From: Jamie Brown [REDACTED]
Sent: 16 December 2019 14:59
To: Michael Eastham <Michael.Eastham@arun.gov.uk>; Bernadette Gledhill
[REDACTED]
Cc: Clark, Robert [REDACTED]
Subject: RE: Littlehampton: CEMP Rev B - LU/339/19/DOC and LU/340/19/DOC

From: Steven Shaw
Sent: 29 November 2019 15:13
To: Michael Eastham; Clark, Robert
Cc: Bernadette Gledhill; Jamie Brown
Subject: RE: Littlehampton: CEMP Rev B - LU/339/19/DOC and LU/340/19/DOC

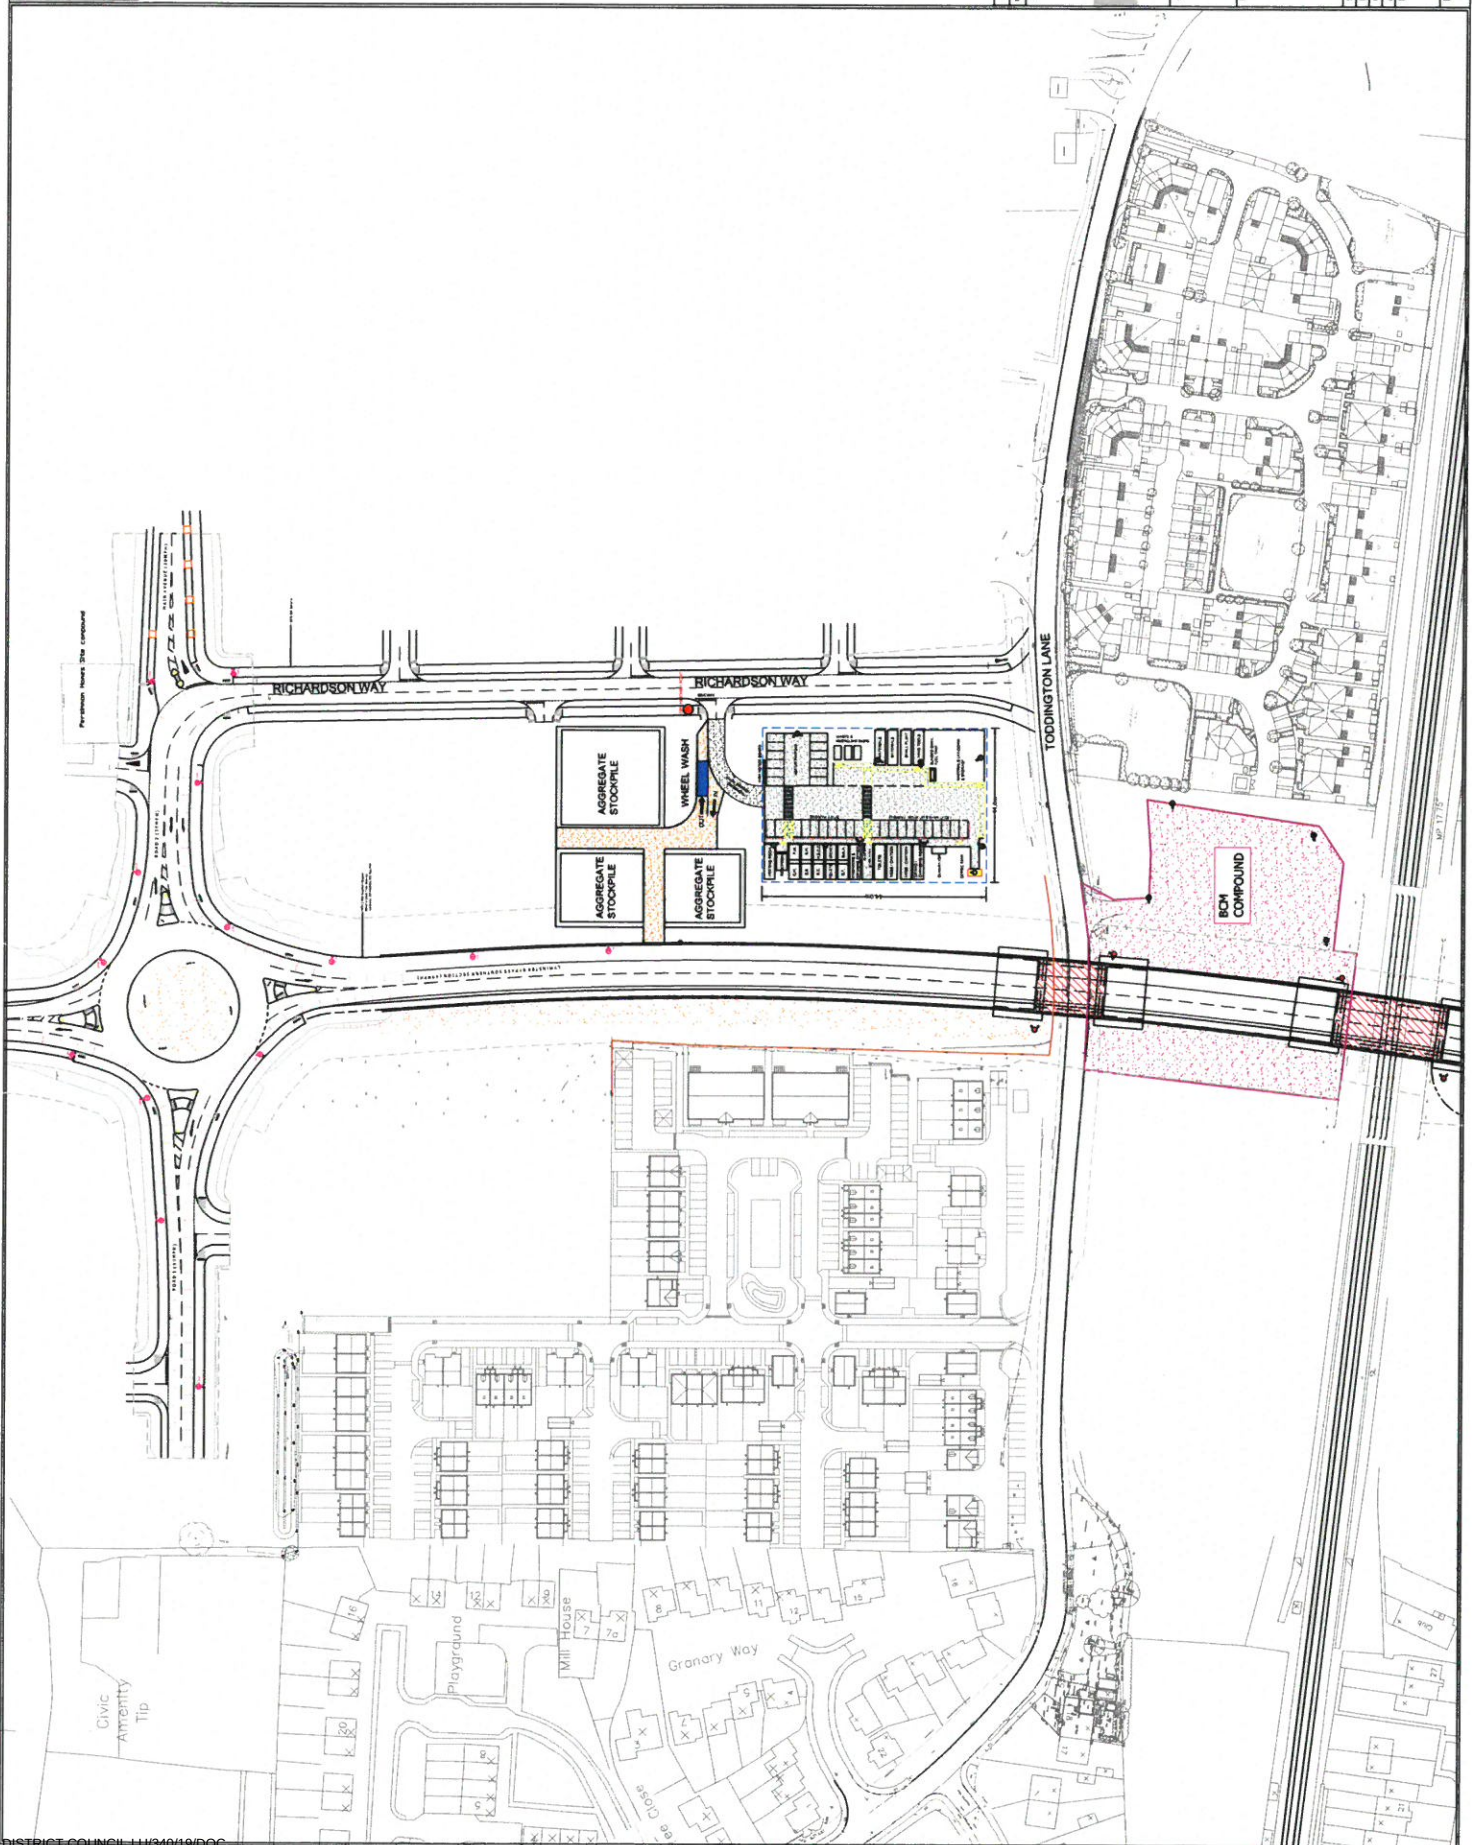
- Parking areas have not been demonstrated i.e not shown or laid out therefore difficult to know how much contractor parking could be housed. Clarification on the level of parking and its design and layout should be provided.
